Recommendation Report for Lawful Development Certificate for a Proposed Use or Development

REF NO: **AW/357/18/CLP**

LOCATION: 4 Trinity Way
 Westmeads
 Bognor Regis

PROPOSAL: Application for a Lawful Development Certificate for a Proposed use - side extension

PROPOSED

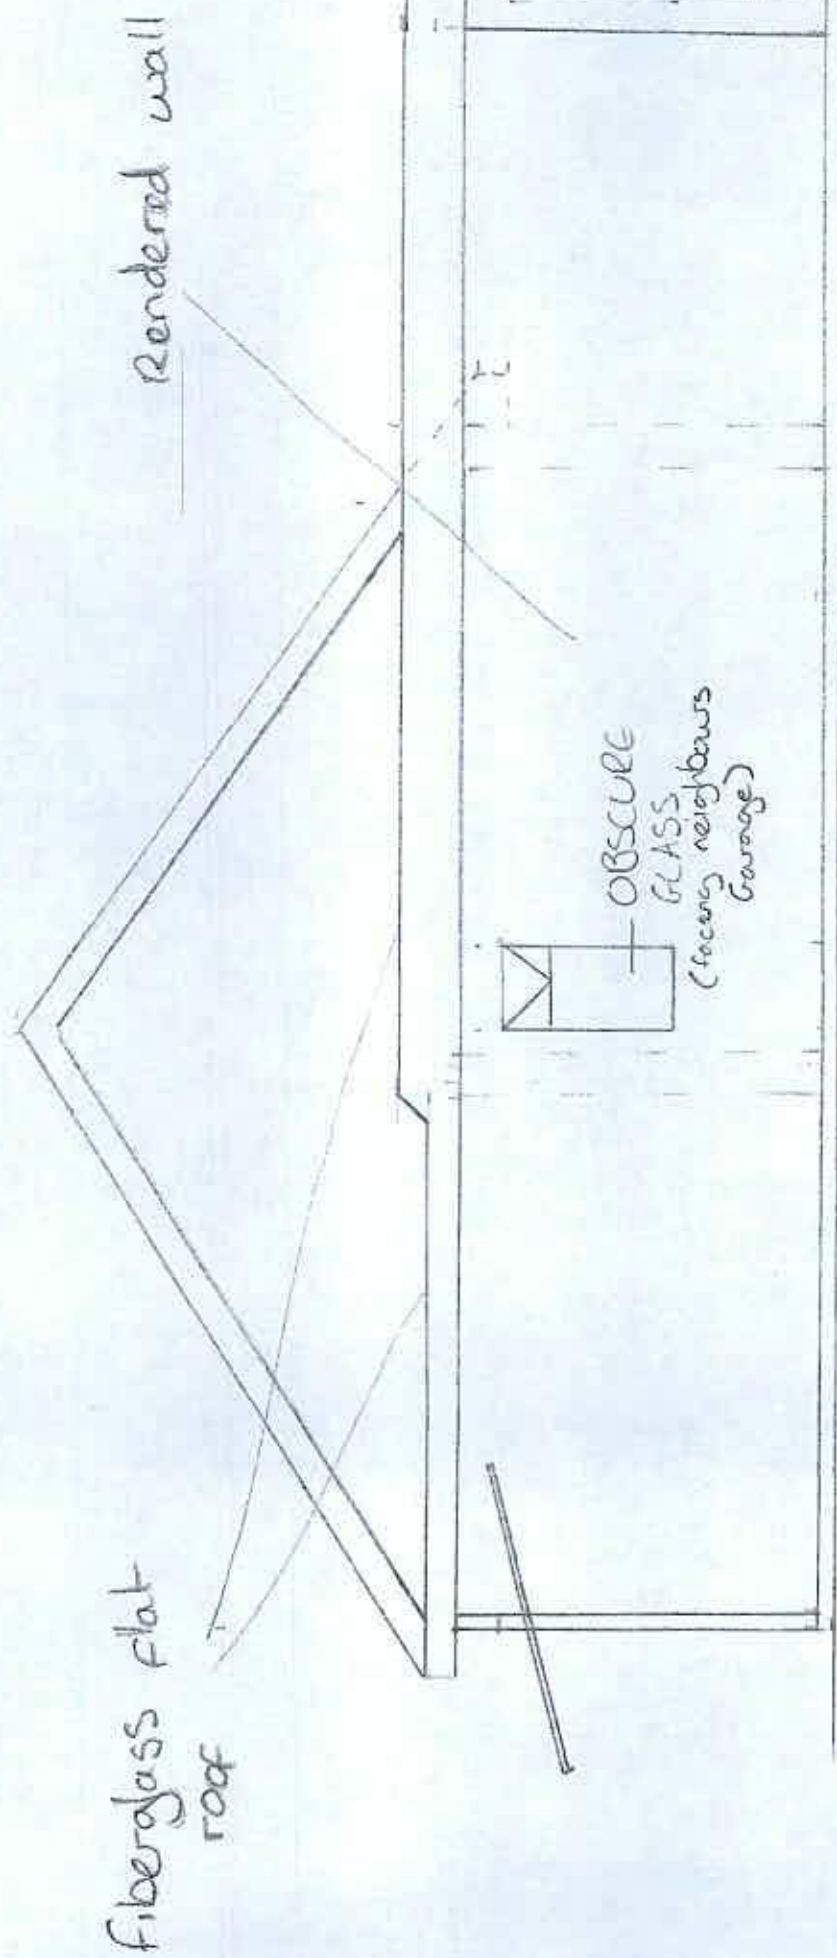
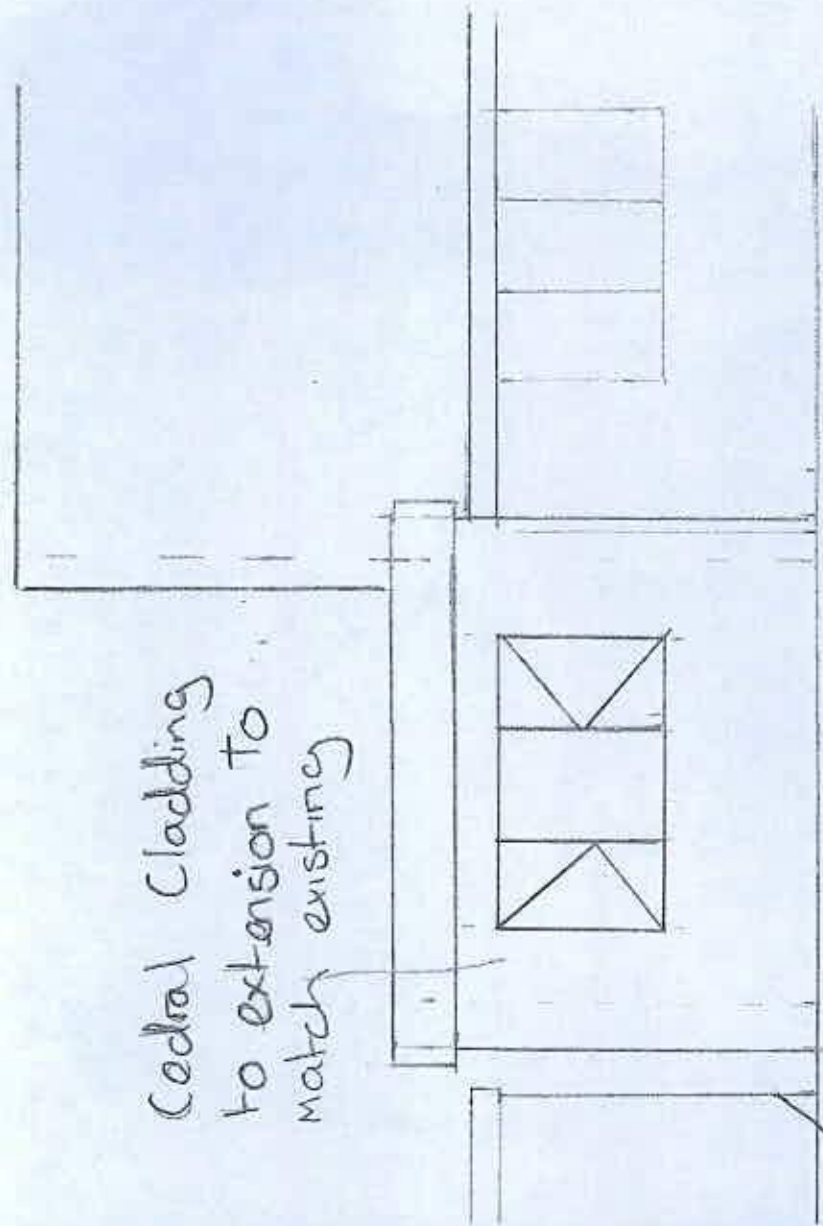
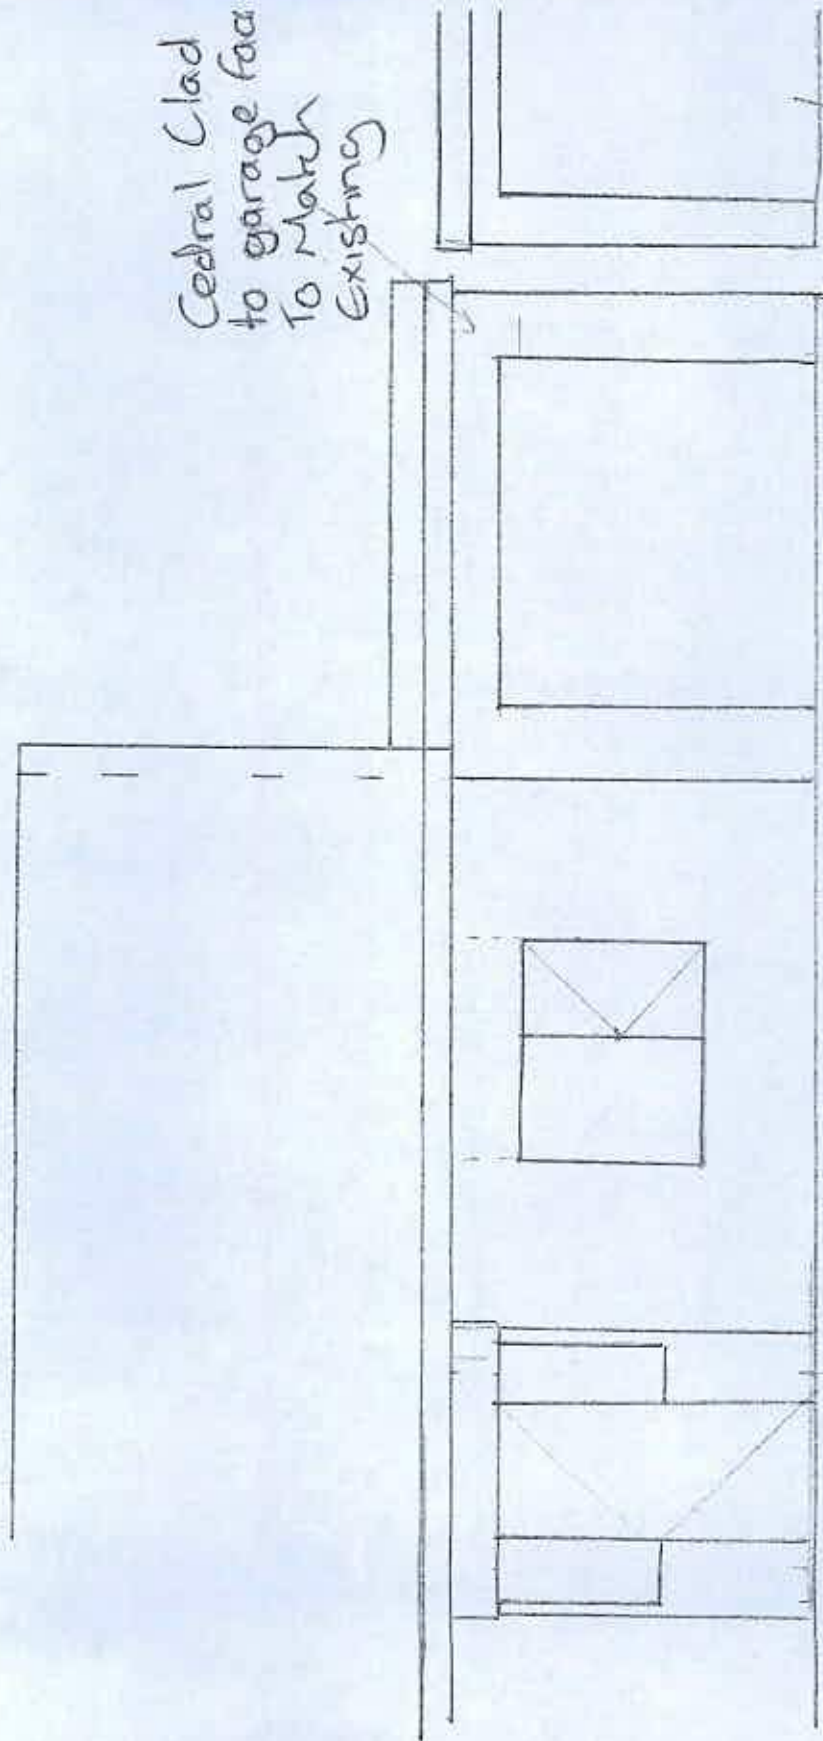
The application seeks a certificate of lawfulness for the construction of a single storey side and rear extension to the side of the property with a flat roof measuring approximately 2.9 metres in height, a side projection of 3.2 metres to within 35cm of the boundary and a length of 10.8 metres projecting 2.8 metres behind the rear elevation of the house.

The proposed single storey side and rear extension is considered to comply with sections (a),(b),(c),(d),(e),(i), (j)(i)(ii)(iii) of Schedule 2, Part 1, Class A of the Town and Country Planning (General Permitted Development) Order 2015 (as amended) and is considered to be "Permitted Development", and as such does not require the submission of an application for full planning permission.

Construction of a single storey side and rear extension from materials of a similar appearance to those of the existing dwellinghouse with a flat roof measuring approximately 2.9 metres in height, a side projection of 3.2 metres to within 35cm of the boundary and a length of 10.8 metres projecting 2.8 metres behind the rear elevation of the house with brickwork front elevation to match the existing front elevation of the dwellinghouse as set out in the email dated 05/02/2019 and the following plans;
